**MODIFICATION REQUEST:
Residential Buildings R8 and R9, Barangaroo South
MP 11_0002 MOD 1**

Secretary's Environmental Assessment Report
Section 75W of the
Environmental Planning and Assessment Act 1979

February 2015

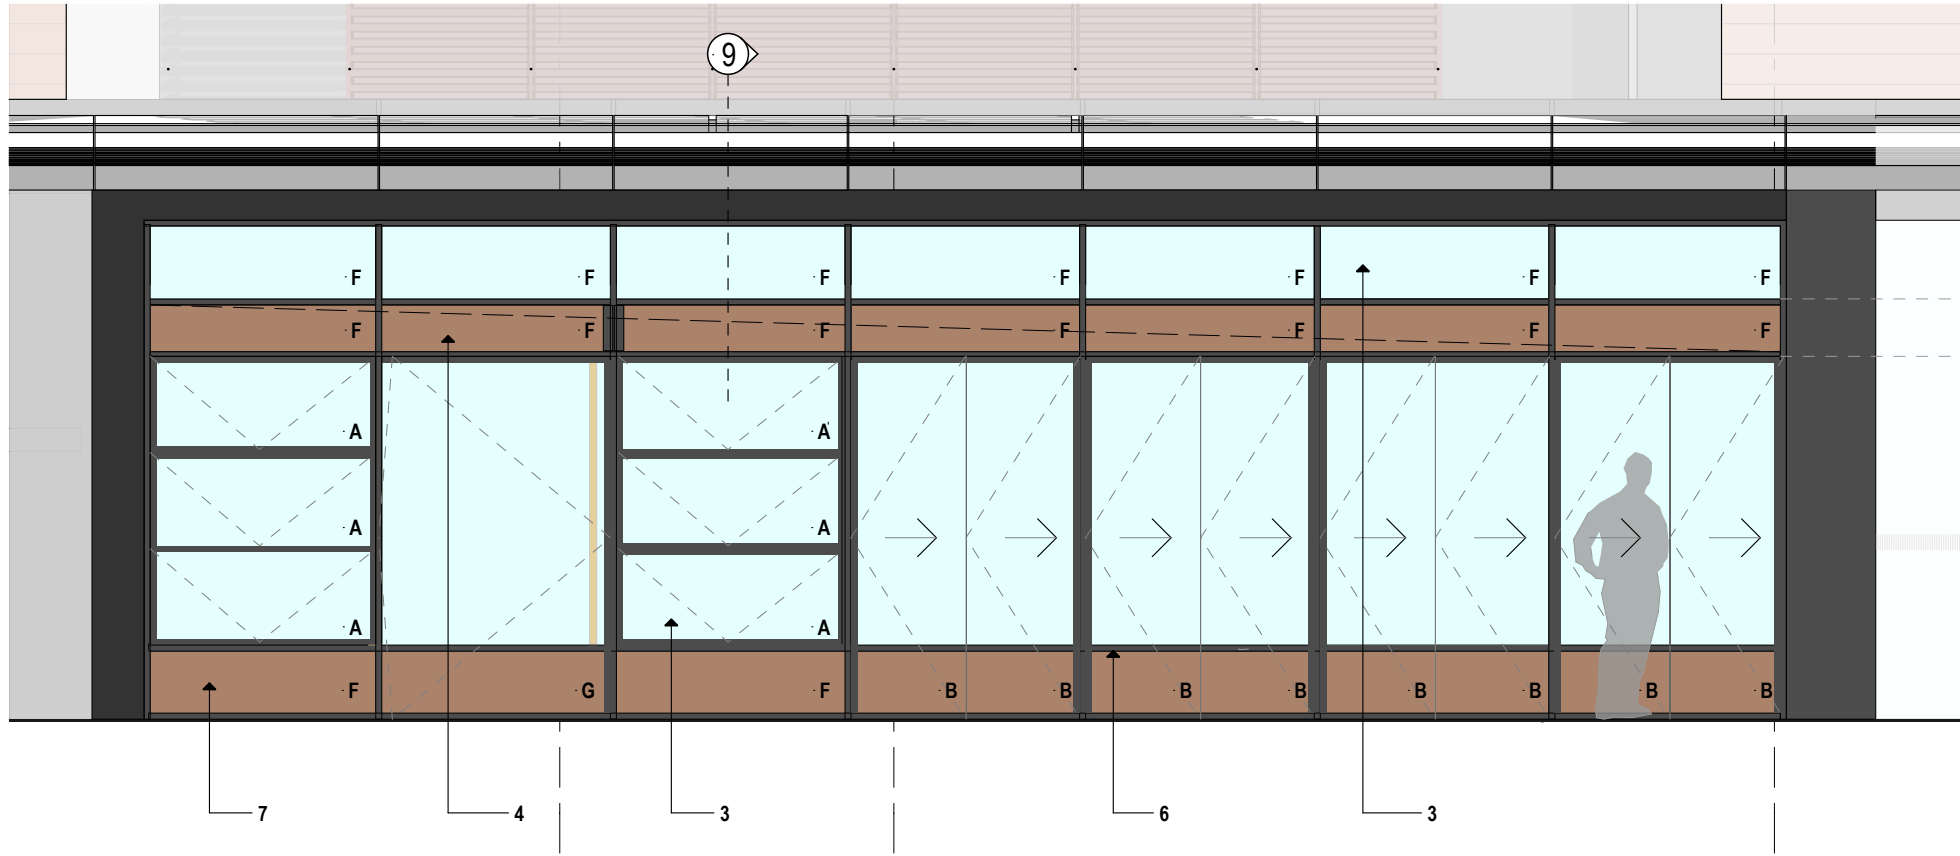
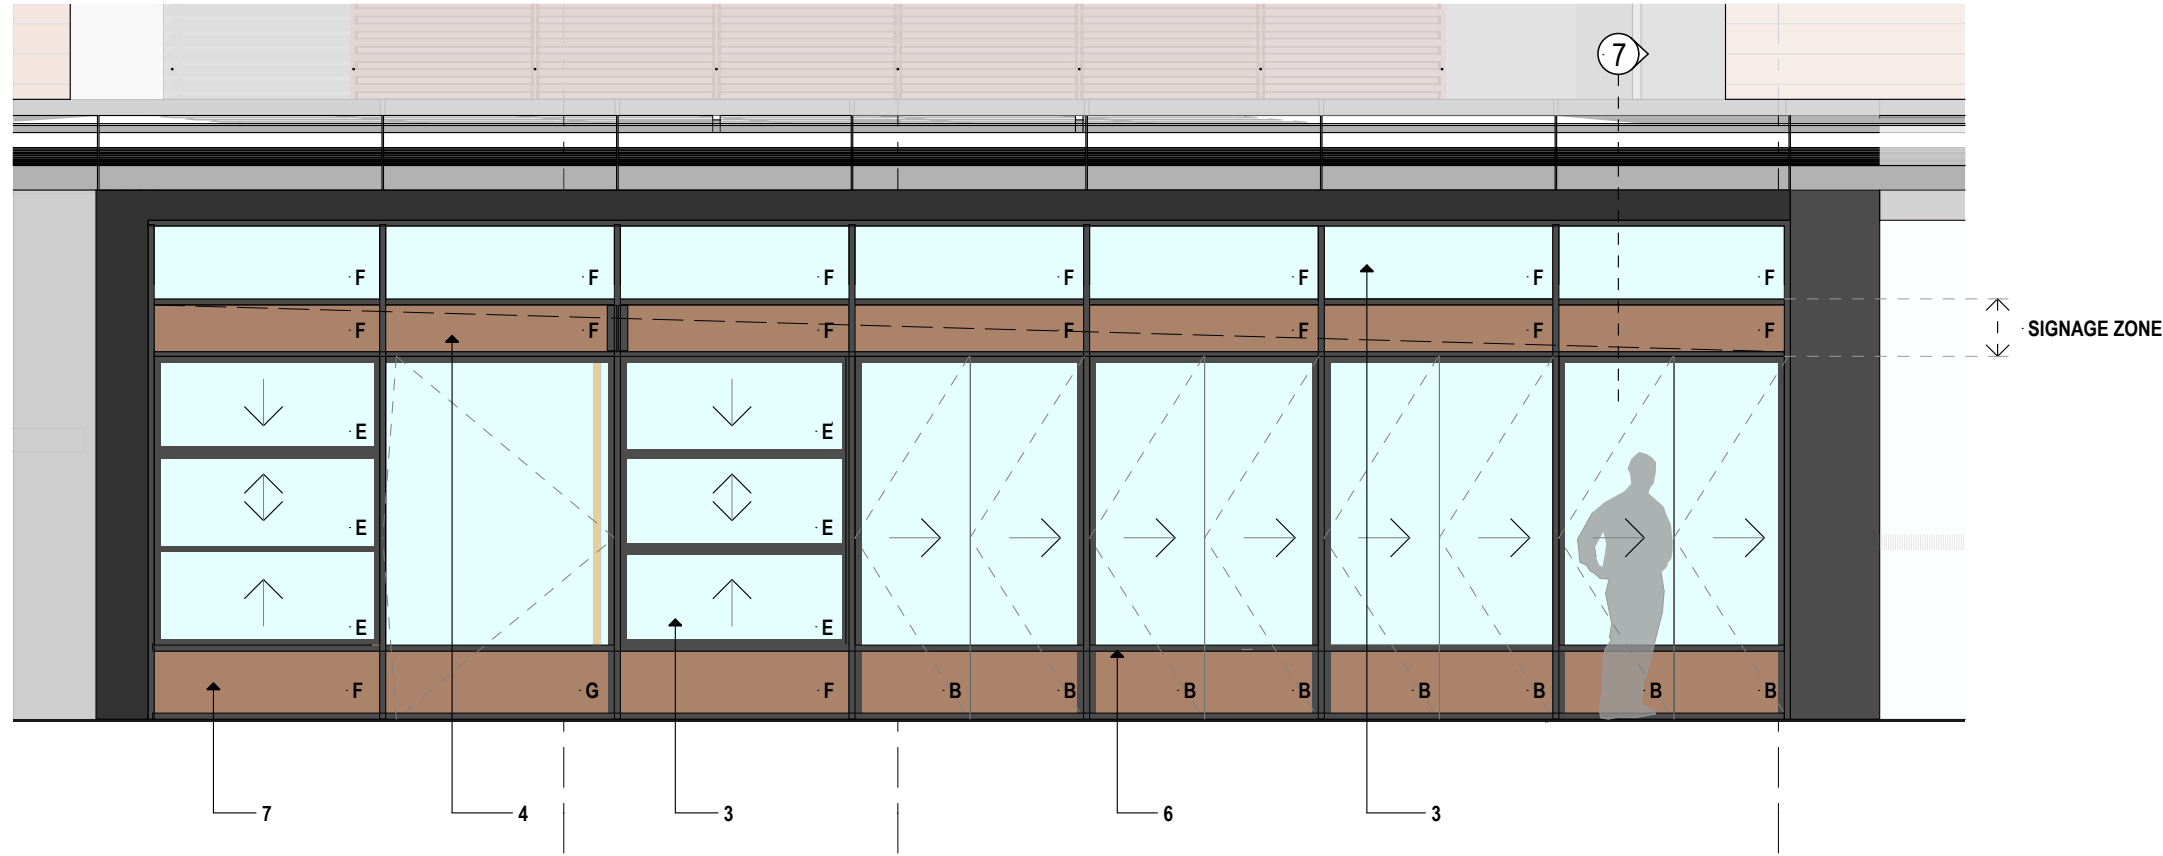
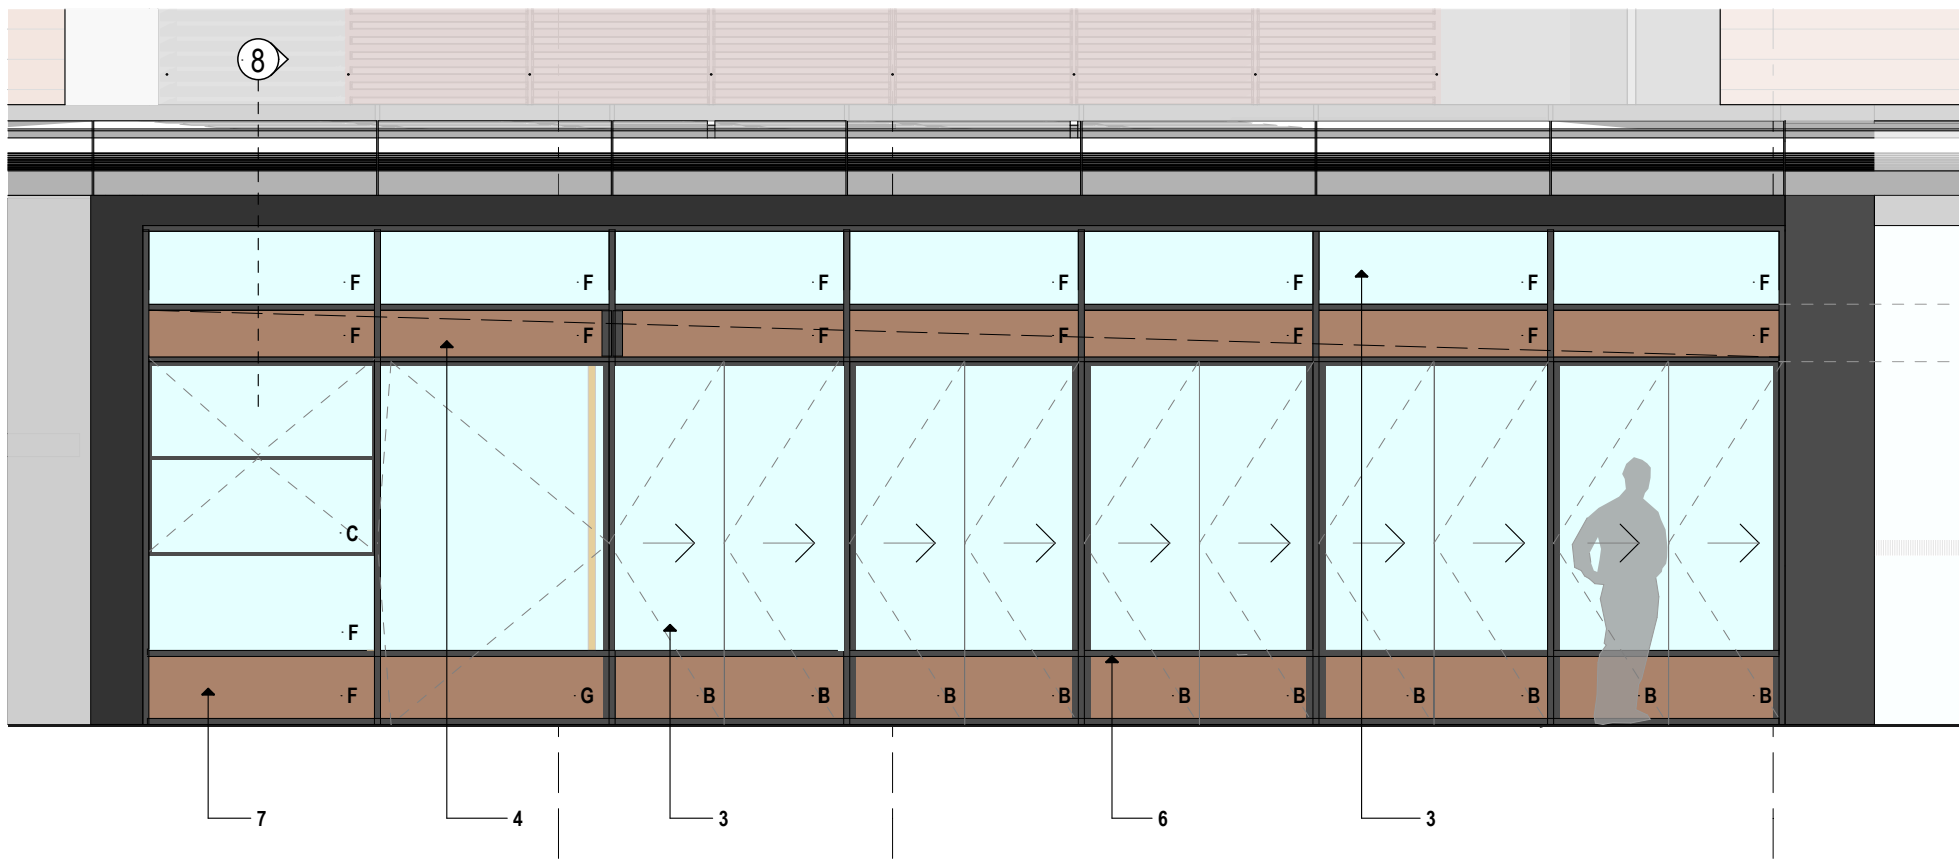
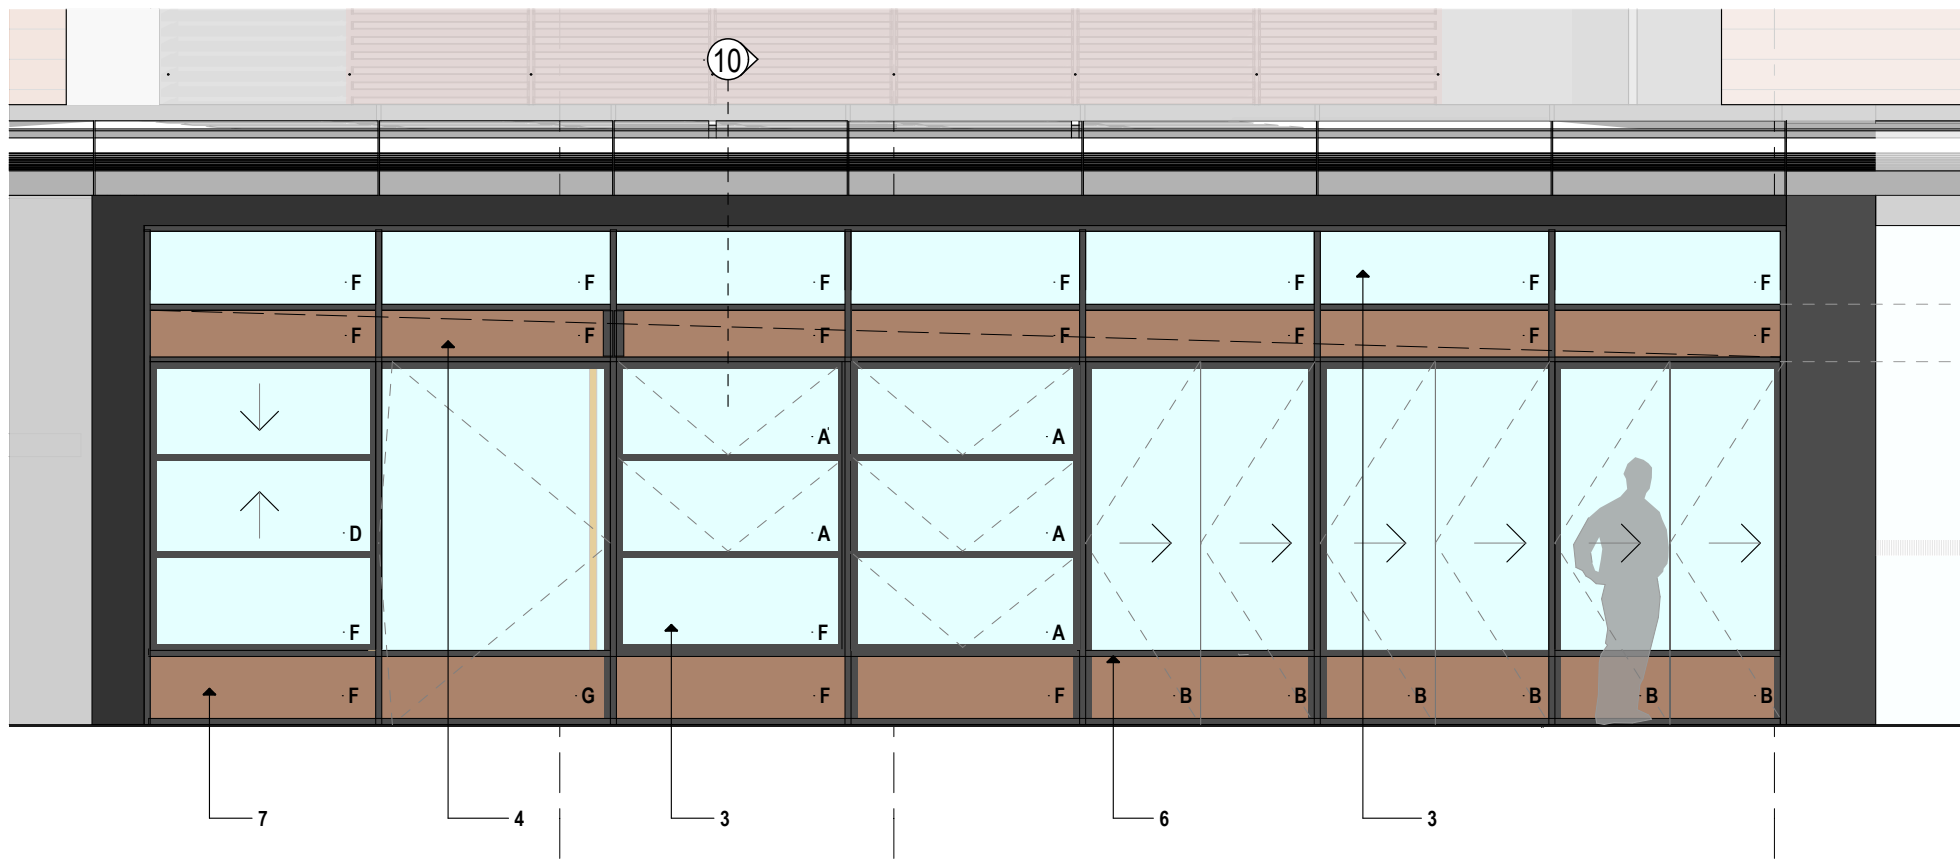
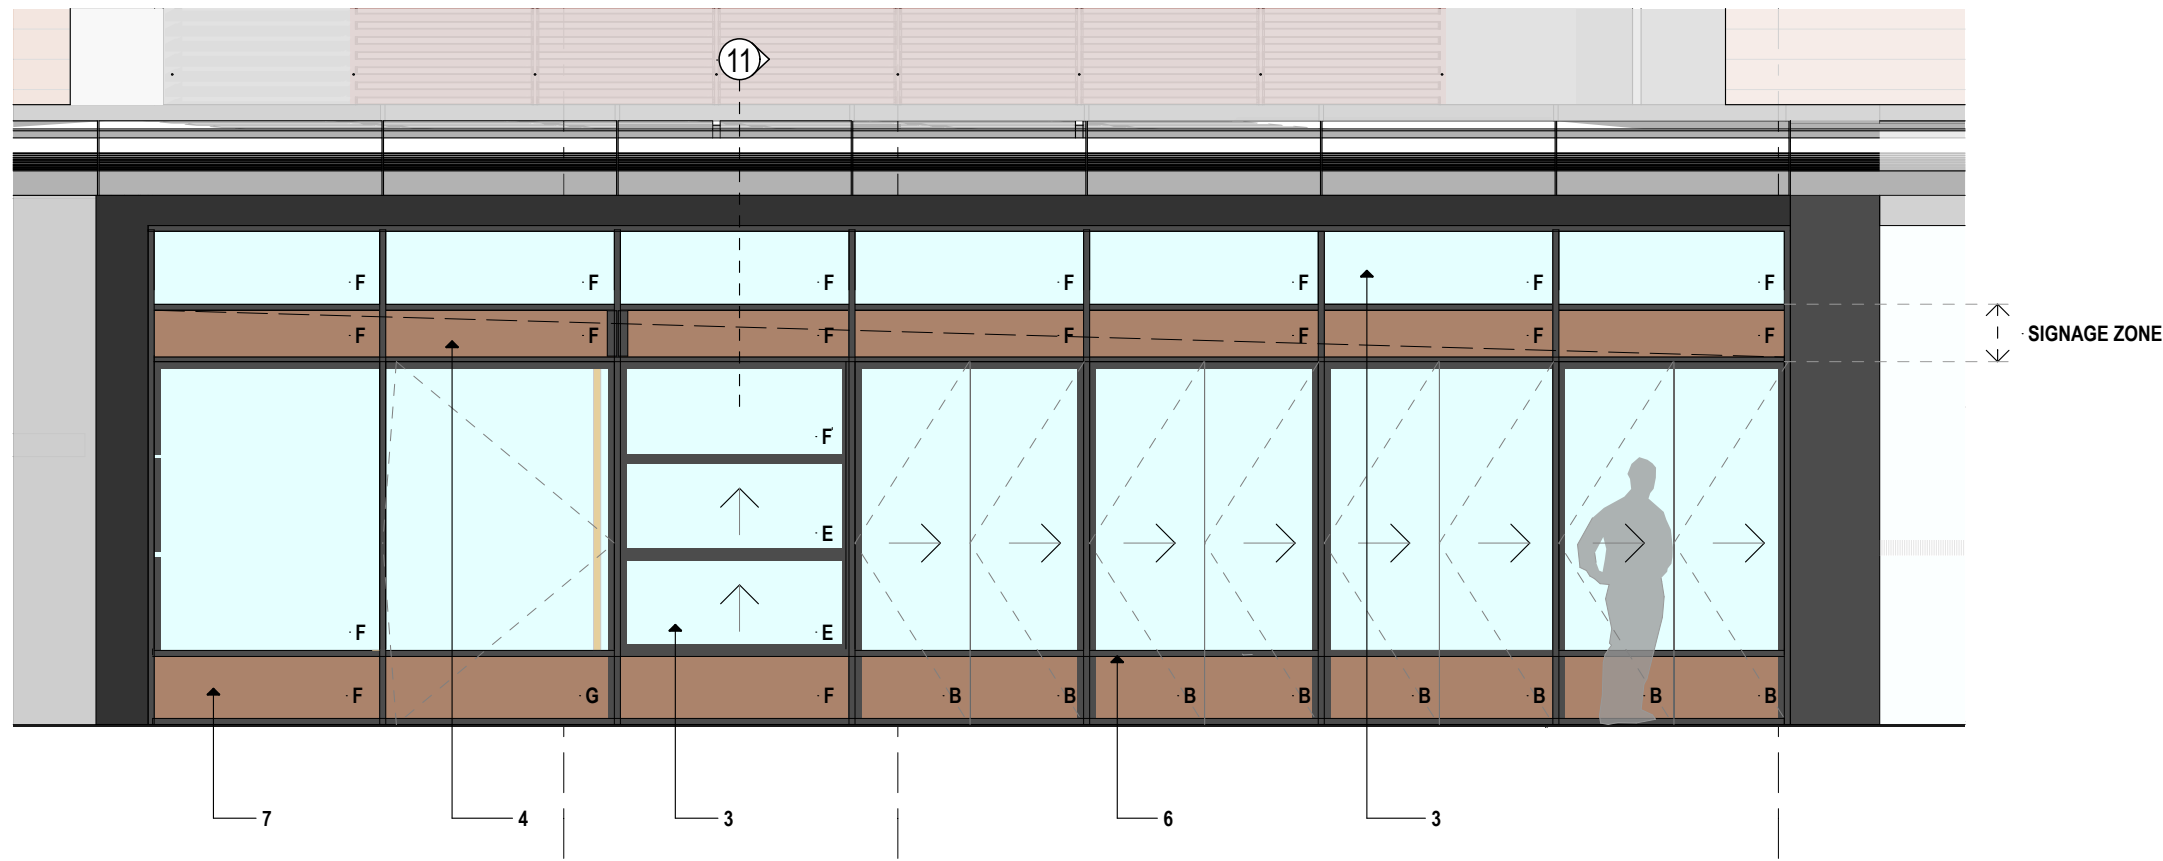
Council raised no objection to the proposed range of retail shop front designs, however, the Government Architect requested further clarification regarding the method for selecting shopfront designs for each of the ground floor retail tenancies. The Department also sought clarification from the Proponent as to whether the retail shop fronts would be constructed under the project approval or as part of the future fit-out applications for the ground floor retail tenancies.

The RTS identified that the retail shop front designs proposed in the modification application are currently only indicative, and that the final detailed designs would be selected by the future tenants according to their design and operational needs. The RTS also identified that the final design of the retail shop fronts would be either undertaken by the Proponent, subject to further approval by the Secretary under the project approval, or the subject of separate future applications by the future tenants themselves. Additionally, the Proponent sought to introduce a new Statement of Commitment (SOC) to secure a framework for the future assessment of the shopfronts for the other elevations (north, south west). The proposed SOC includes general design parameters for each of the shopfronts, namely:

The Department considers that the indicative retail shop front designs with various combinations of glazing and pivot entry and bi-folding doors would generally provide an acceptable outcome for the ground floor retail areas of the buildings fronting Lime Street. The Department also acknowledges the need to provide flexibility for future tenants to tailor the final design of the shop fronts to their needs, and is generally satisfied with the proposed SOC and general design parameters for the shopfronts for the other elevations. Notwithstanding, to provide clarity in the approval, the Department has recommended modifying a number of conditions to specify that no approval is granted to the
